Date: February 7<sup>th</sup>, 2023  
Subject: Correction Notice #1  
Project: 6221 83rd PI SE, Mercer Island  
MI project # CAO 22-013, SUB 1

The following are issues and responses raised in the first correction round:

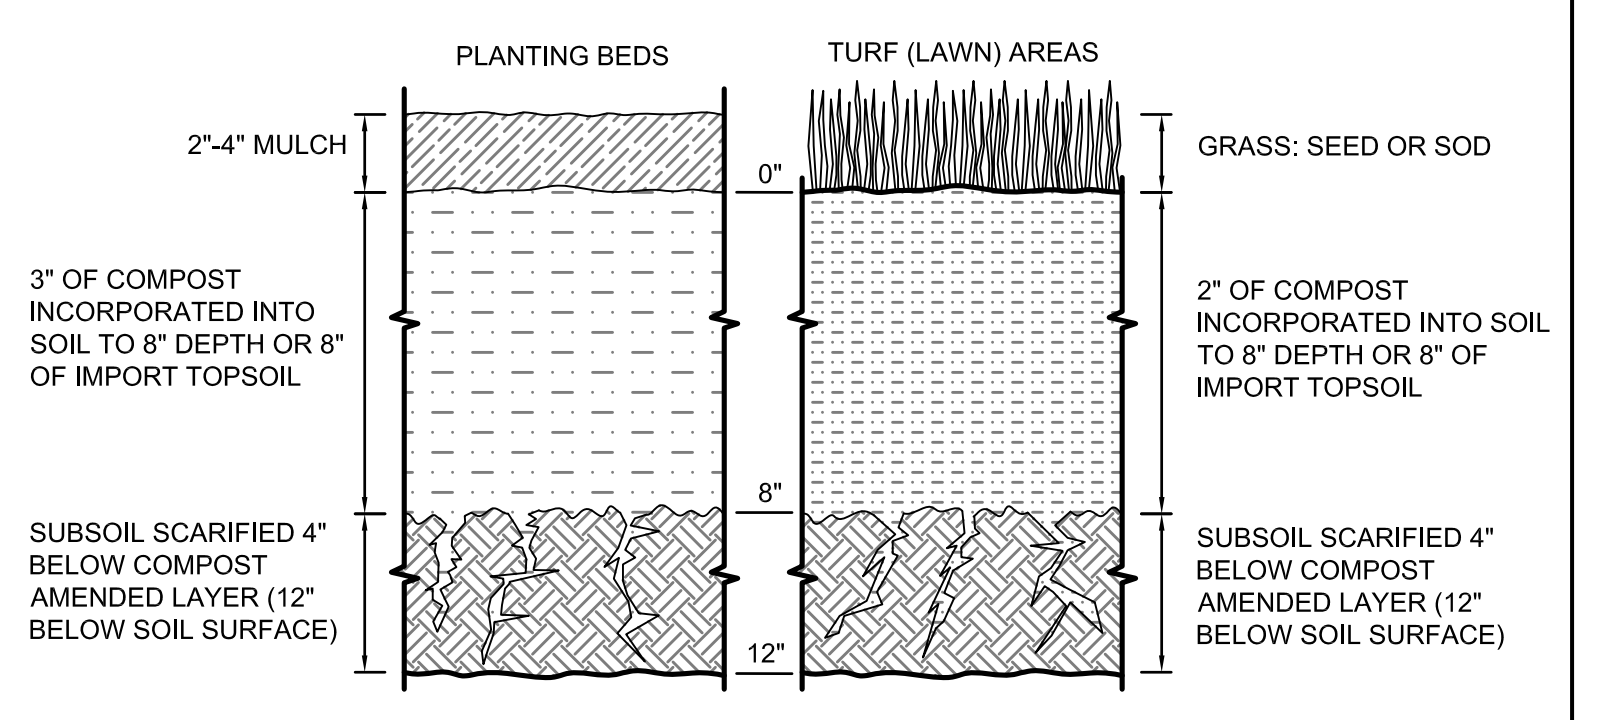
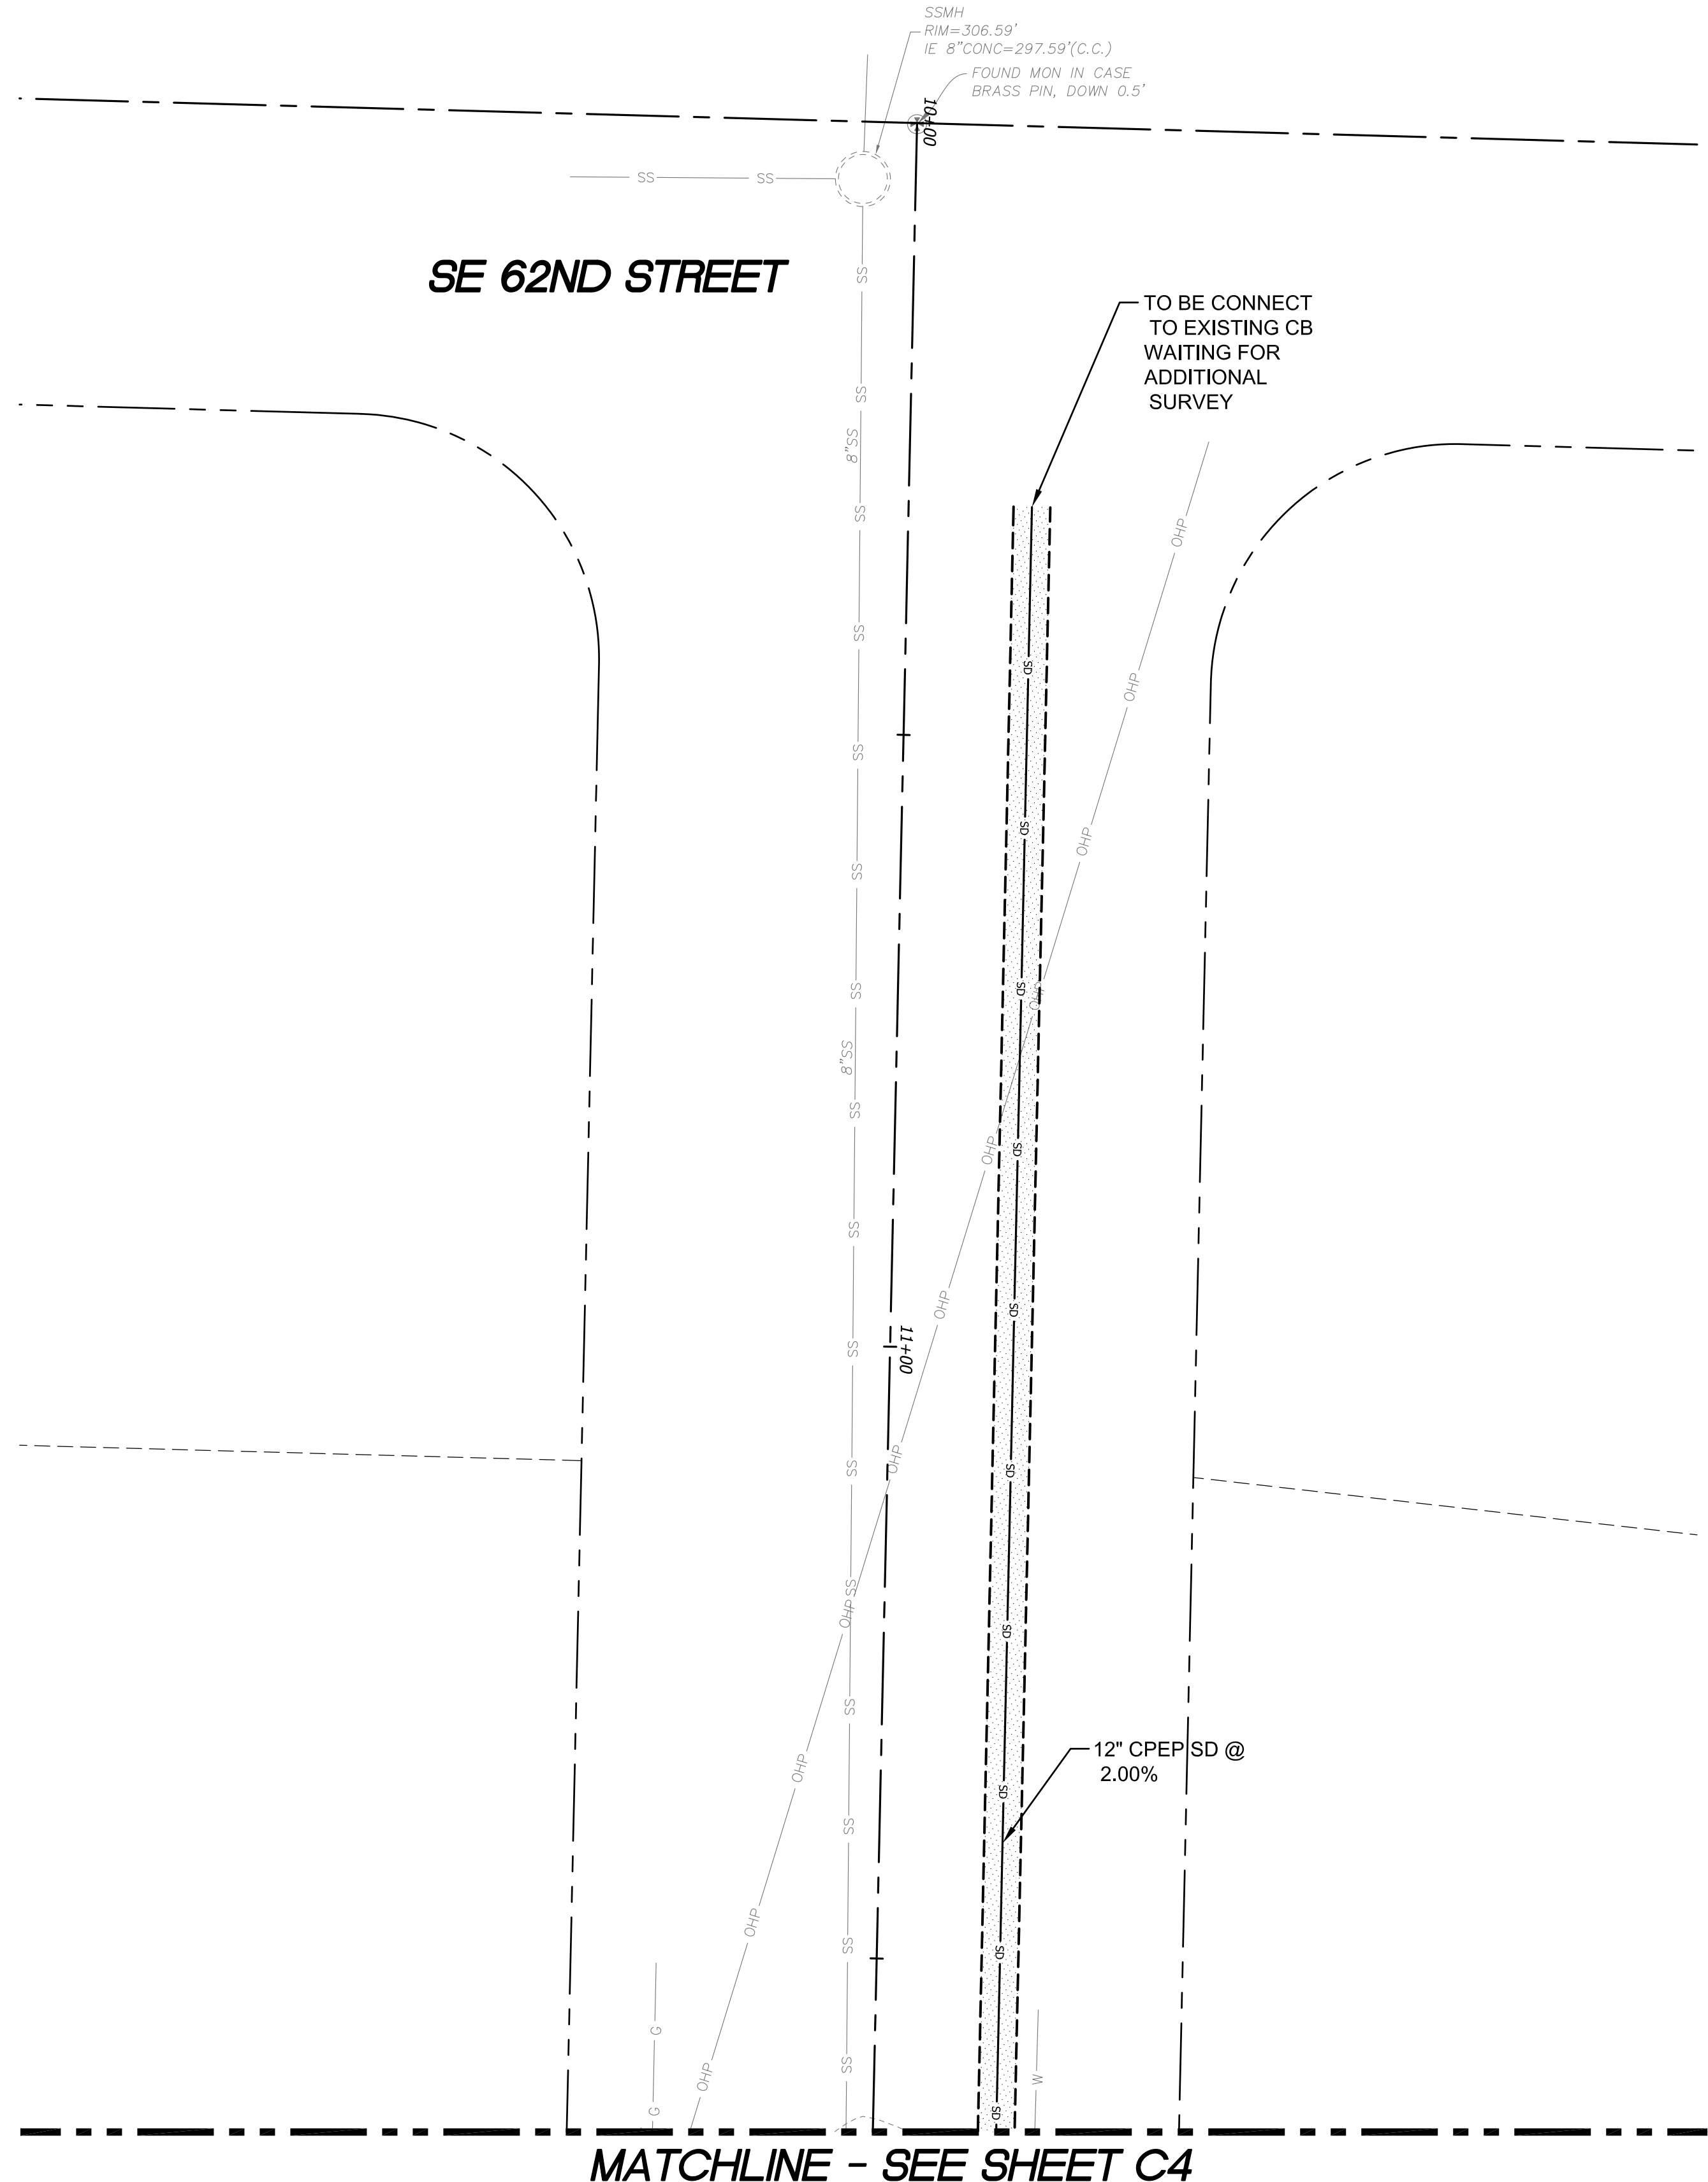
1. Summary: The CAO SUB1 drawings should be reviewed by the geotechnical engineer of record with the dispersion elements specifically discussed with any design modifications recommended by the geotechnical engineer. Following their review or any design modifications, an updated statement of risk (MICC 19.07.160.B.3) should be provided by the geotechnical engineer. Once these items are resolved, it is our opinion that the design would meet the requirements of MICC 19.07.160.
  - a. Please see the Geotech consultant's letter in response to these items. Thank you.
